From: Richard Martin
Sent: 19 October 2017 14:43
To: Zac Denton
Cc: Juan Baeza
Subject: FW: R/1/17/T
Attachments: BROOKENBEE CLOSE.R.1.17.T.pdf; COWDRAY DRIVE.R.1.17.T.pdf; HUTCHISON.SUMMERLEY.FOXES.R.1.17.T.pdf; WATERSMEAD DRIVE.R.1.17.T.pdf

To: Richard Martin
Cc: Joe Russell-Wells; Sue Howell
Subject: R/1/17/T

WATERSMEAD DRIVE

PARKLANDS / COWDRAY DRIVE

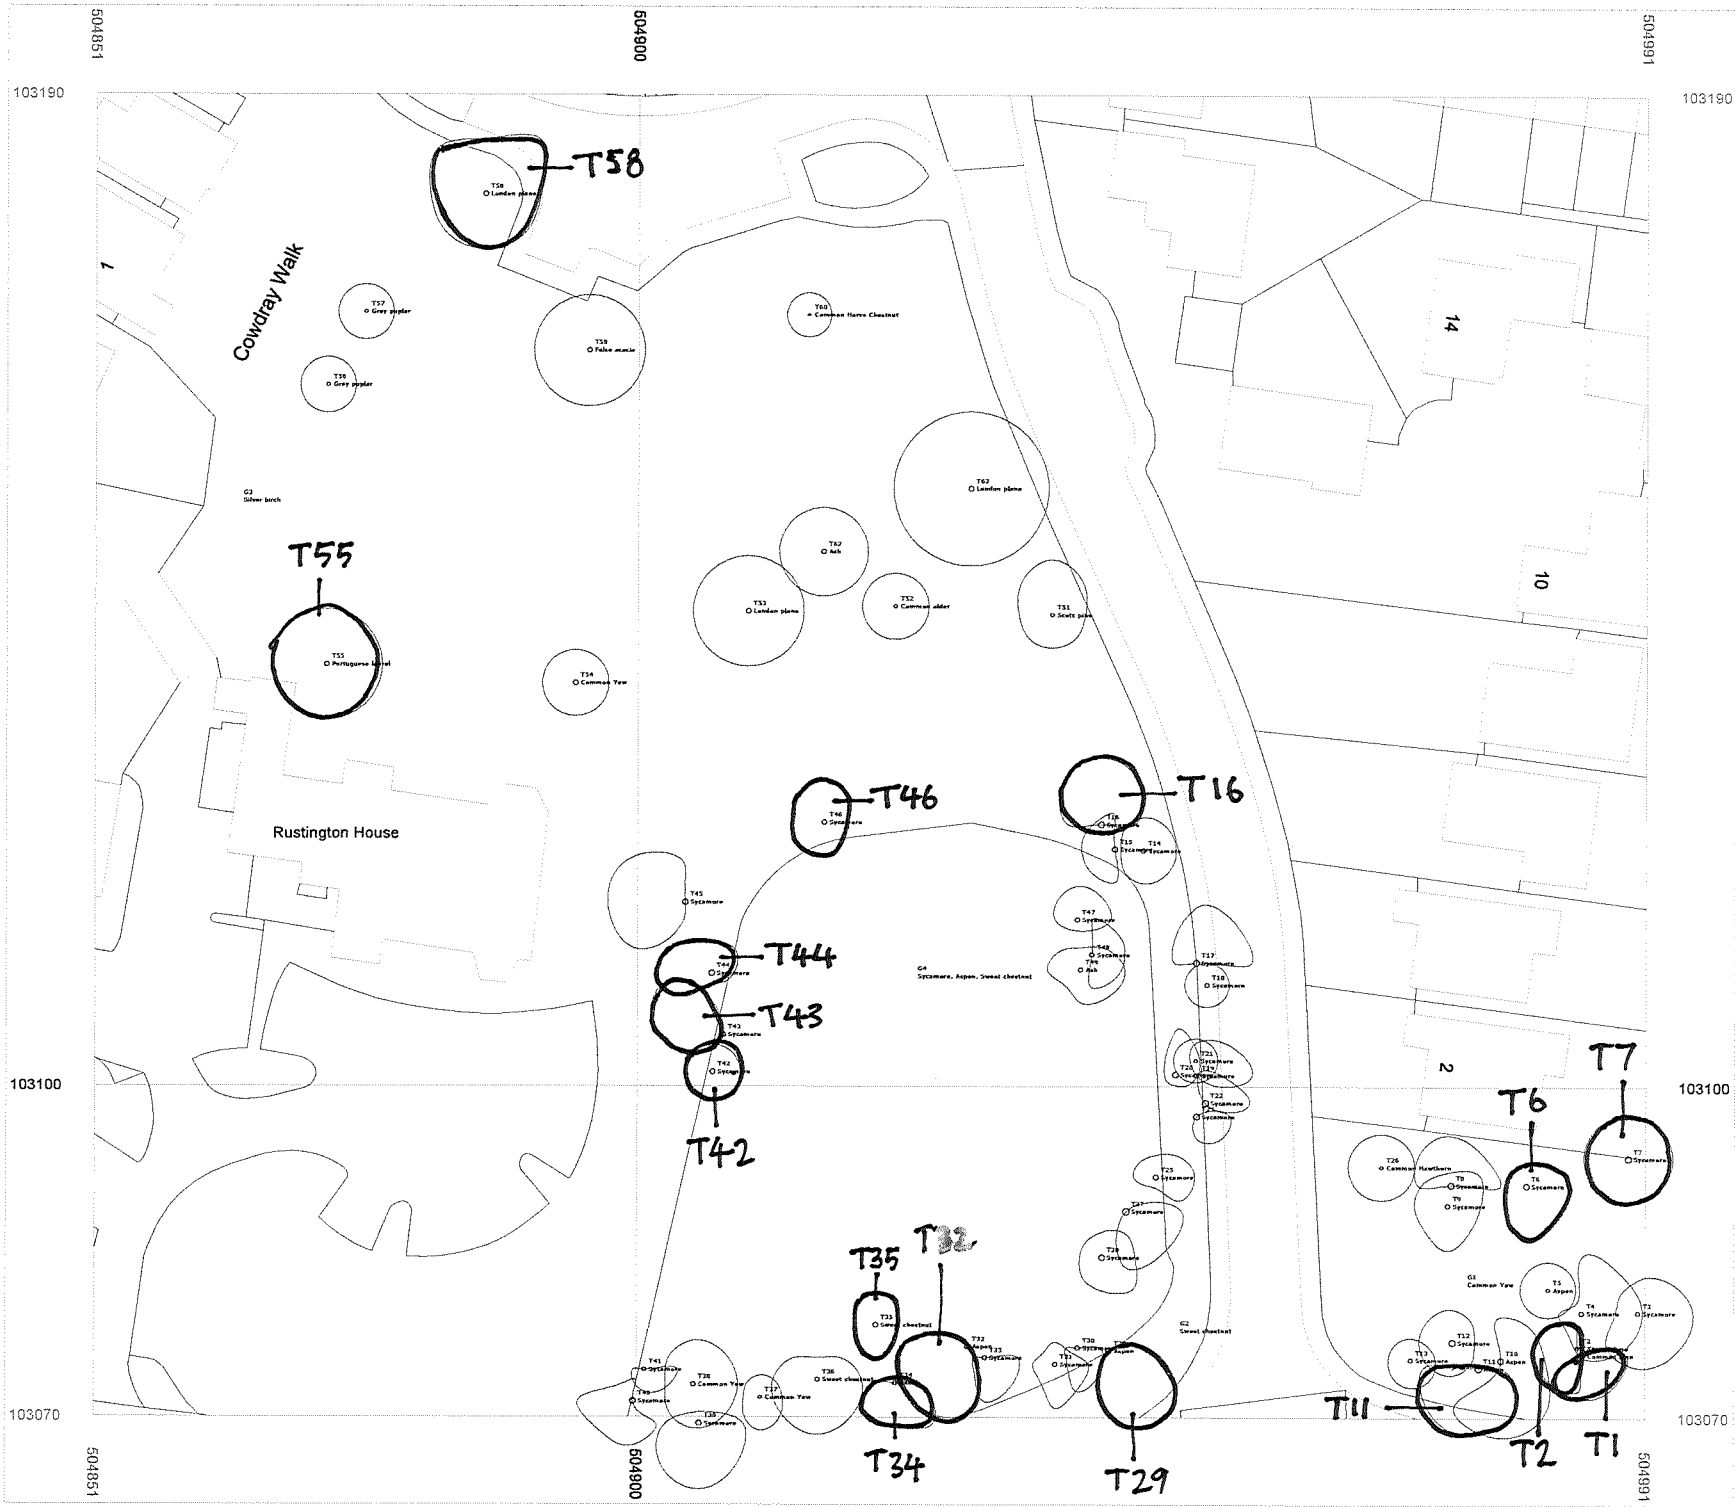
No.	Species	Work Applied For	Works Approved	Works Refused	Advised Works For Re-Submission
T1	Lime	Remove epicormic growth	Remove basal suckers	-	-
T2	Lime	Remove epicormic growth	Remove basal suckers	-	-
T6	Sycamore	Reduce faulted limbs/stems squirrel damaged	-	-	Need a climbing inspection report with photographs to highlight the degree of damage – plus need more specific details i.e. how many branches in total would be reduced? How much would be taken off the ends of each branch? Otherwise we would be agreeing to this blind and the tree could be devastated and its amenity value undermined by the amount of branch loss?
T7	Sycamore	Reduce faulted limbs/stems squirrel damaged	-	-	Need a climbing inspection report with photographs to highlight the degree of damage – plus need more specific details i.e. how many branches in total would be reduced? How much would be taken off the ends of each branch? Otherwise we would be agreeing to this blind and the tree could be devastated and its amenity value undermined by the amount of branch loss?

T11	Aspen	Reduce faulted limbs/stems rubbing branches. Reduce crown by 3m away from light.	Reduce crown by 3m away from light.	Reduce faulted limbs/stems rubbing branches	Need a climbing inspection report with photographs to highlight the degree of damage – plus need more specific details i.e. if its rubbing branches then how many are there and which of each pairing will they be removing. Otherwise we would be agreeing to this blind and the tree could be devastated and its amenity value undermined by the amount of branch loss?
T16	Sycamore	Reduce faulted limbs/stems crossing branches.	-	Reduce faulted limbs/stems crossing branches.	Need a climbing inspection report with photographs to highlight the degree of damage – plus need more specific details i.e. if its crossing branches then how many are there and which of each pairing will they be removing. Otherwise we would be agreeing to this blind and the tree could be devastated and its amenity value undermined by the amount of branch loss?

T29	Aspen	Reduce crown - laterals 3m height 2m	Reduce crown - laterals 3m height 2m	-	-
T32	Aspen	Reduce crown – reduce southern crown by 2m to 3m	Reduce crown – reduce southern crown by 2m to 3m	-	-
T34	Beech	Reduce faulted limbs/stems remove squirrel damaged lateral branches	-	Reduce faulted limbs/stems remove squirrel damaged lateral branches	Need a climbing inspection report with photographs to highlight the degree of damage – plus need more specific details i.e. if its squirrel damage alone then they need to state how many branches are affected. Otherwise we would be agreeing to this blind and the tree could be devastated and its amenity value undermined by the amount of branch loss?

T35	Sweet Chestnut	Fell southern stem	Fell southern stem	-	-
T42	Sycamore	Fell eastern stem	Fell eastern stem	-	-
T43	Sycamore	Remove leaning stem from trunk	Remove leaning stem from trunk	-	-
T44	Sycamore	Fell	Fell – no replacement tree will be required in this instance	-	-
T46	Sycamore	Fell	Fell – no replacement tree will be required in this instance	-	-
T55	Portugal Laurel	Reduce crown away from property Cut and remove where possible wire	Cut and remove where possible wire	Reduce crown away from property	How much reduction- dimensions required?
T58	London Plane	Raise low canopy – 5m over road	-	5m is excessive and would undermine visual amenity value of tree in the landscape	I appreciate that the road clearance is important so tip back the lateral overhang to the road edge and then above the footpath crown raise to 2m
